From: Simon Davis
Sent: 16 August 2019 16:03
To: Planning Scanning
Subject: FW: BR/73/19/PL 3 Houses at Royal Norfolk Hotel

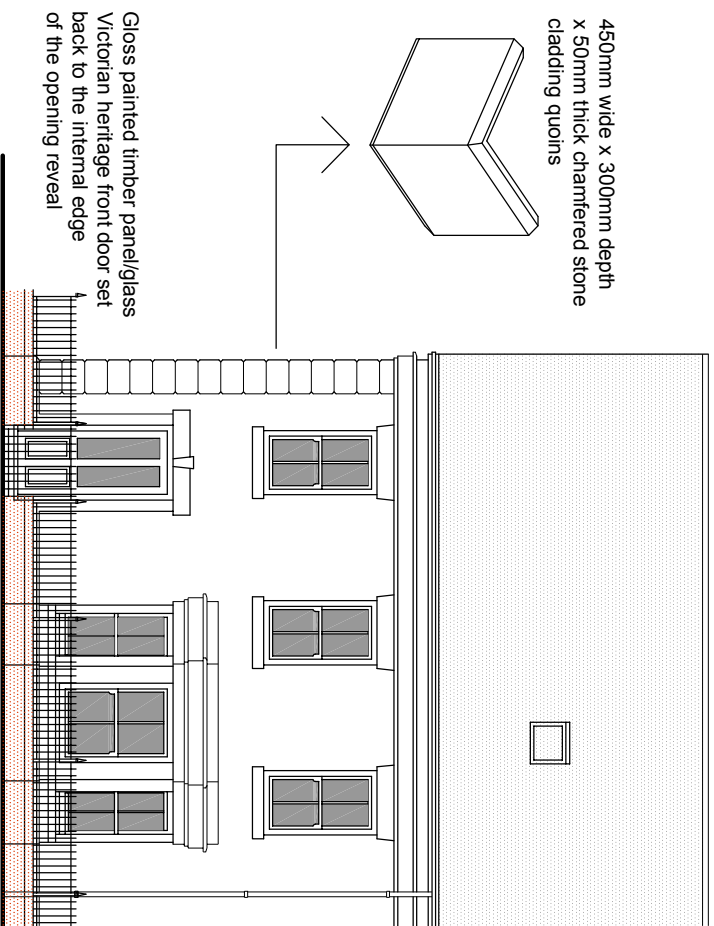
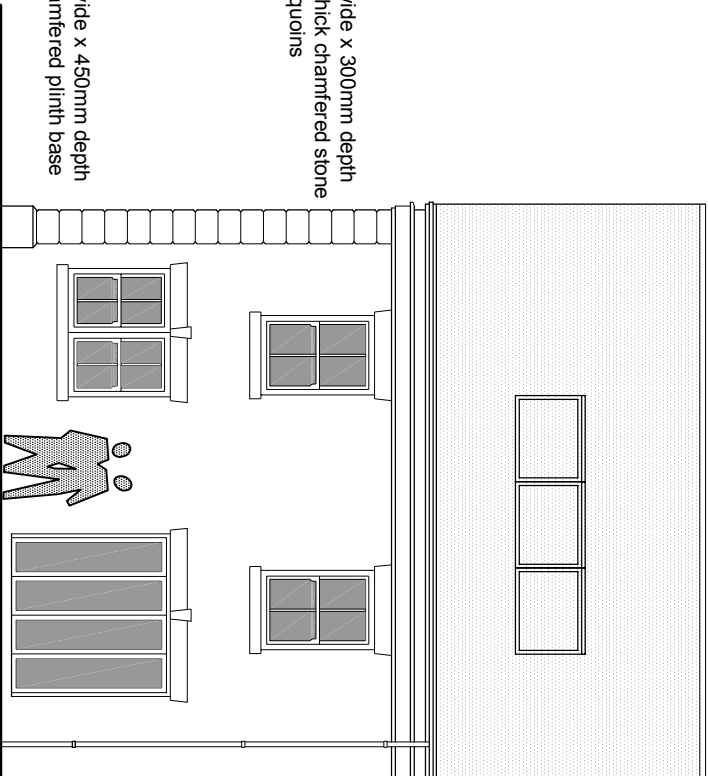
I have spoken to Martyn about the bay windows and as long as the GF bay window detailing is continued upwards, he has no objections. I also don't consider that there will be any need to reconsult as the change is trivial.

He has also commented that most/all other properties in West street have double/triple height bay windows (however, he has not asked for this to be changed).

If, as I understand, the Group Head is now demanding a further 21 days notification in respect of the upper bays, causing yet further delays until October, in which case, I will not include them. Accordingly, please find attached an amended 'street scene' omitting the upper bays in accordance with the original scheme. As it happens, it is of little matter to me which of the alternatives the Council prefer, but either way, I do not want it to result in any further delays beyond the committee meeting of the 5th September.

Please find plans and elevations amended with double bay windows, together with street scene showing the houses to the north of the site on the west side of West Street.

I will be happy to amend the front elevations to double height bay windows in accordance with Group Head's comments, but I would not wish to delay determination with re-consulations?
